3/14/14

Met w/ Shawn Binger
to review past comments
& proposed resubmittal
Items for him to follow
up before Resubmittal

**LOT 3-A, GILETTE ADDITION
GRADING AND DRAINAGE PLAN**

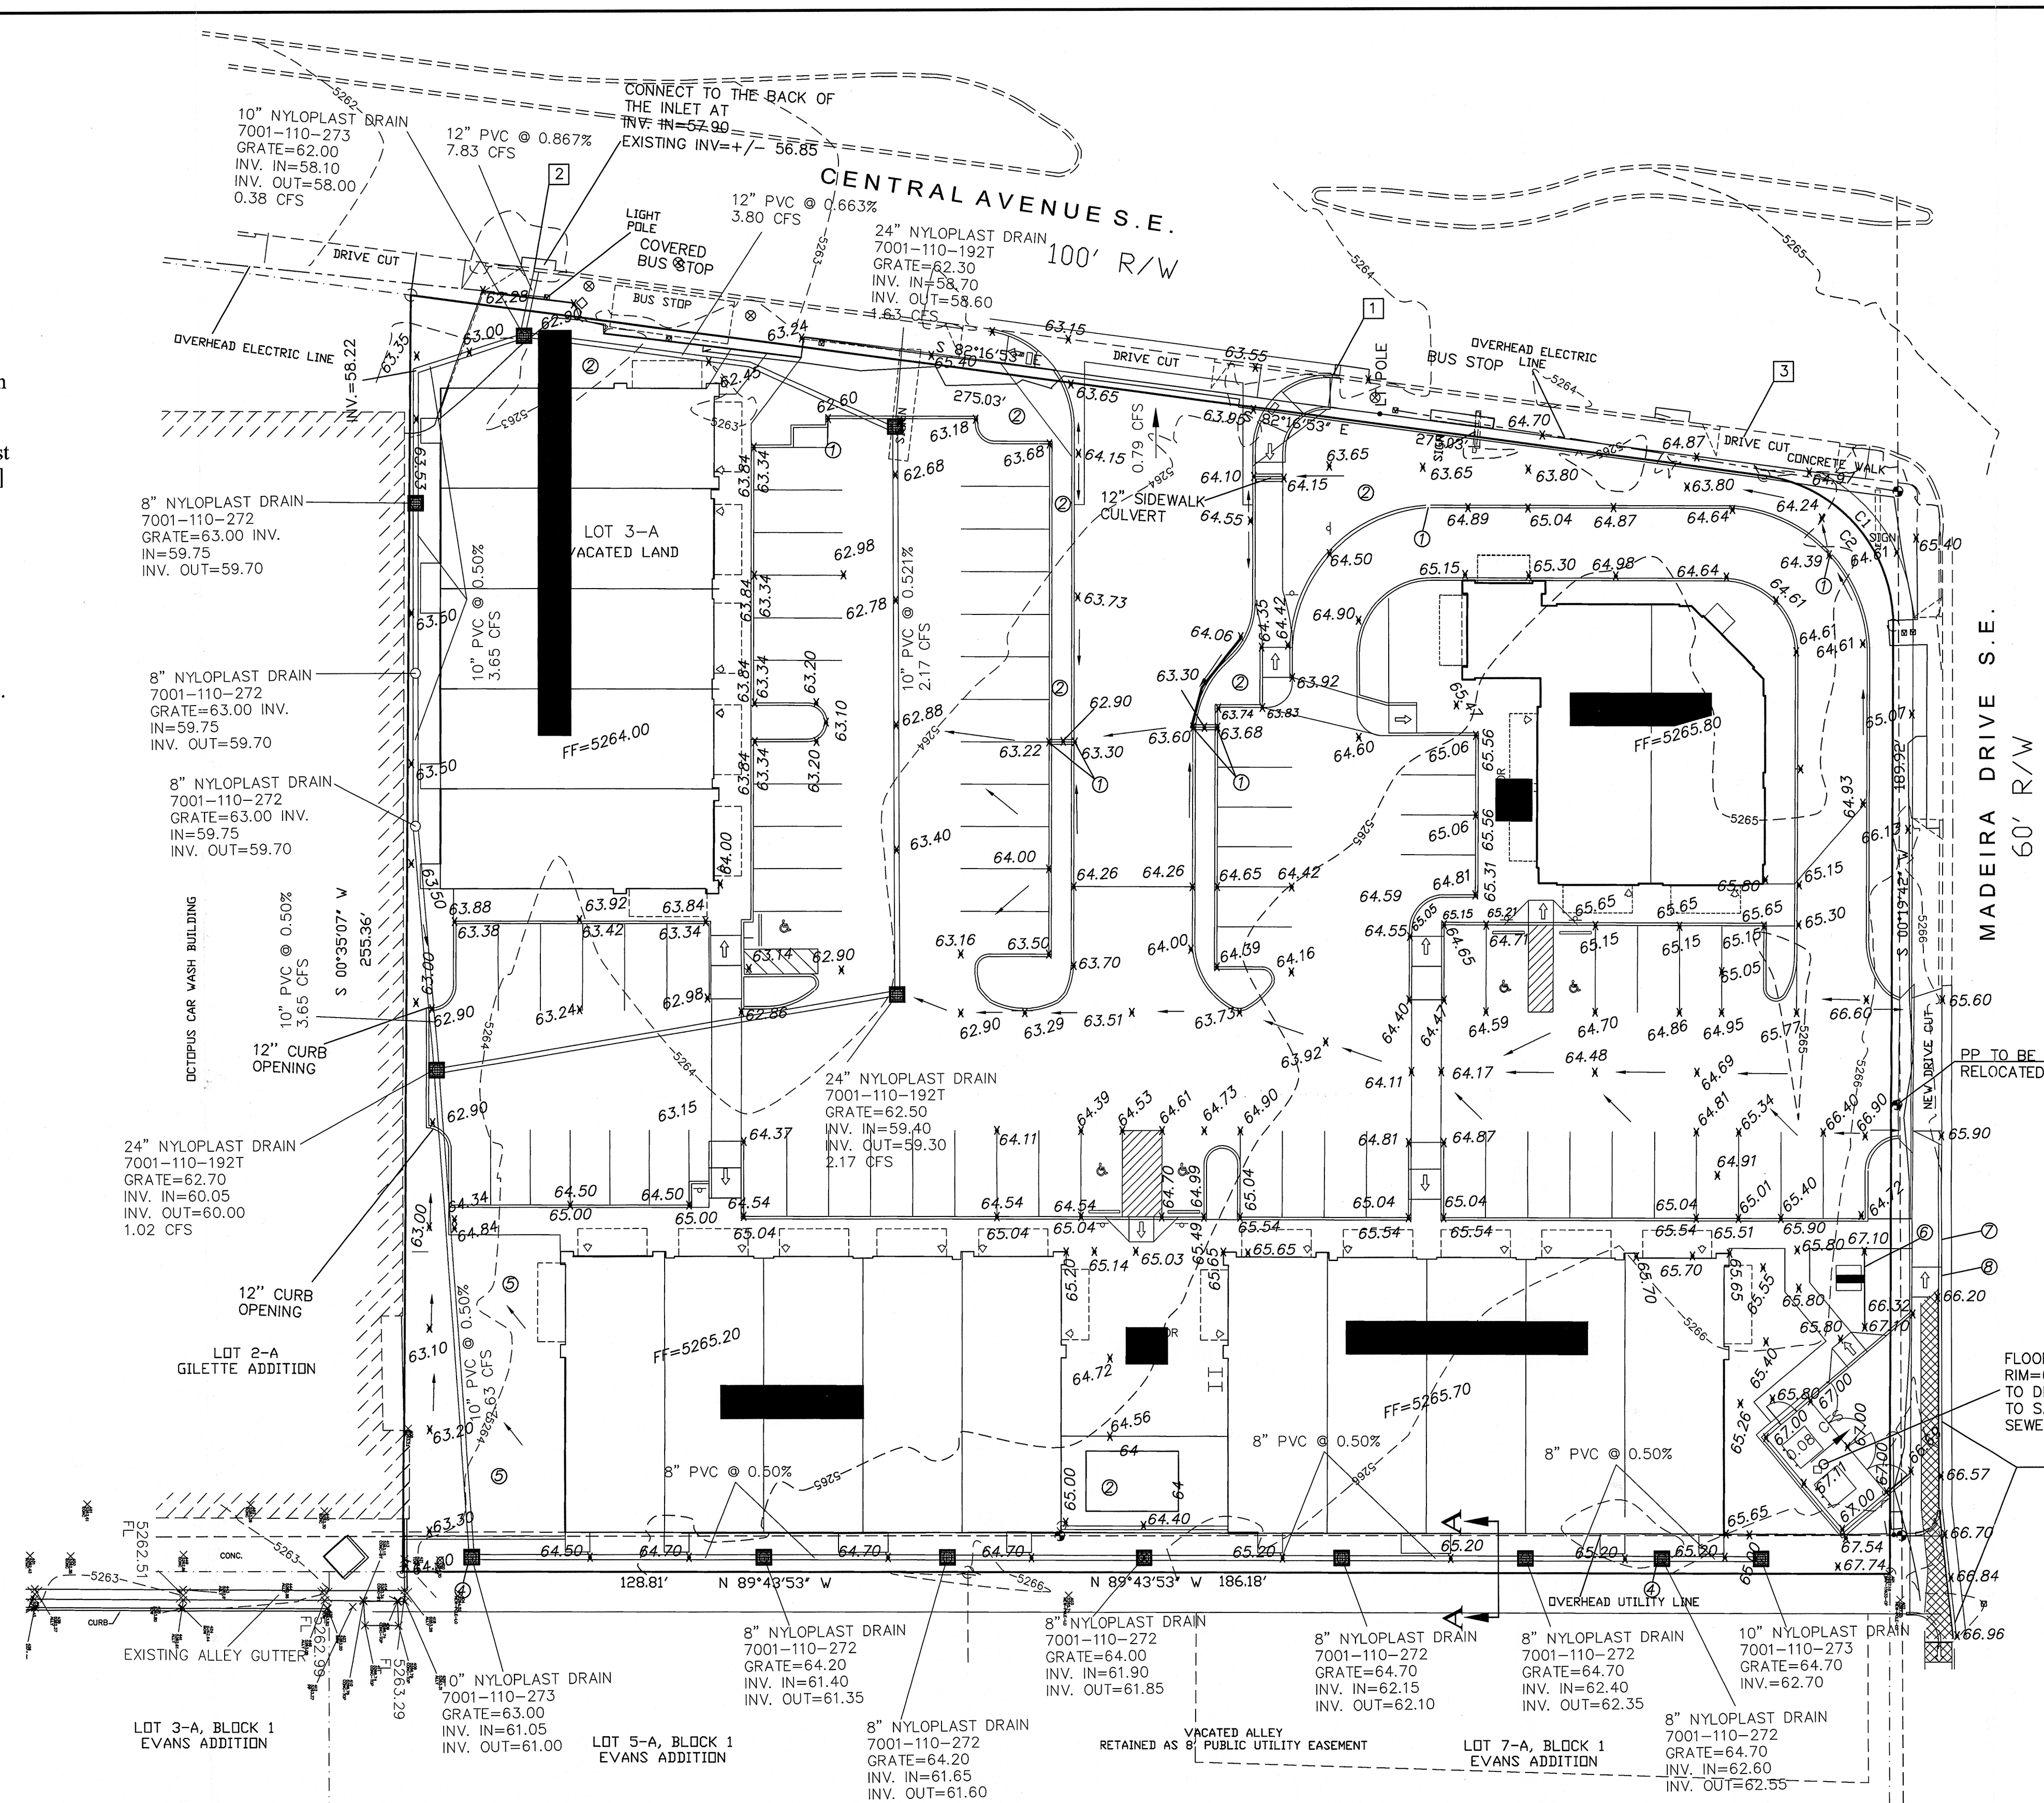
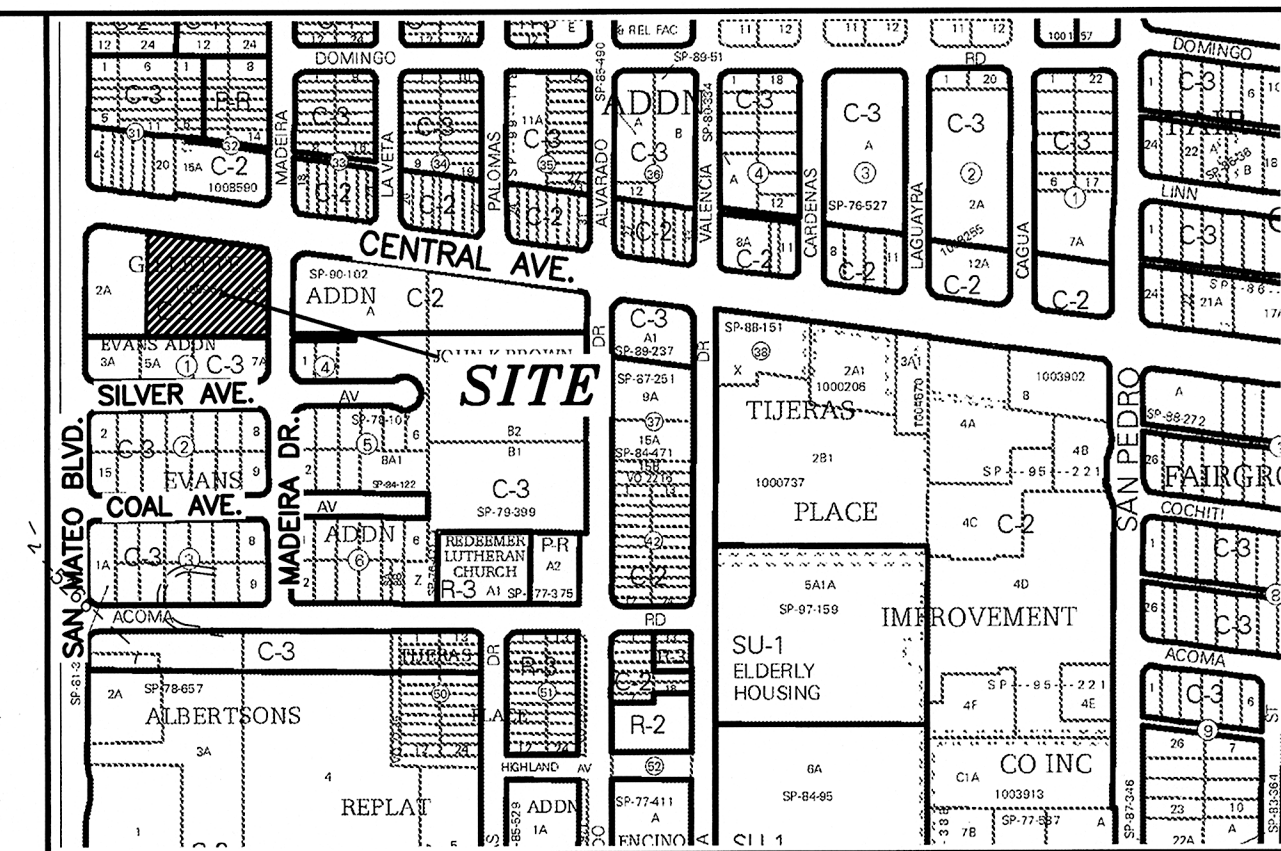
- ① Ensure water block near
mountable curb in Madira
- ② Provide typ. Section in
vacated alley. He'll propose
Crusher Fines to Cinnelli
to protect Nyopla stone
drains

- ③ Try to Discharge the S. Roof
drain line to a depressed
Landscape area at west
end of Shops to Harvest &
set outfall pipe @ N side
of Landscaping Aug

④ Add a curb cut
in NE Loop to
Depressed NE Landscape
area.

- ⑤ Pumpster from to
San Sewer - shown to
get util. Plan from
Roger Cinelli.
